**Consultation Response from KC,
Trees**

2023/91768 land off, Netherley Drive, Marsden, Huddersfield, HD7 6HL

Erection of 2 dwellings

Date Responded: 28/11/2023

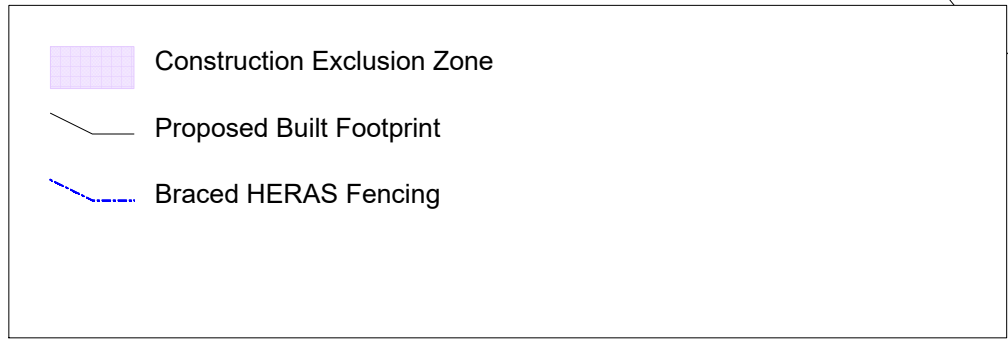
The trees survey appears to have made a fair assessment of the trees along the southern boundary.

I don't think the AIA has covered some aspects of the proposed. Trees agree that the proposed likely could be built without significantly impacting on the trees. However, it would have been helpful to have a more detailed assessment of the proposed ground level changes to facilitate plot 2 and the surround land that could encroach into the RPAs of the neighbouring trees.

Trees are concerned that the position and orientation to the woodland/group of trees along the south boundary of the site will be or at least considered to be oppressive to plot 2 once occupied. Leading to pressure from residents to prune, remove and/or thin the woodland/group out in order to address nuisances.

These could be things like shading, seasonal debris and apprehension about size, proximity, and potential failure.
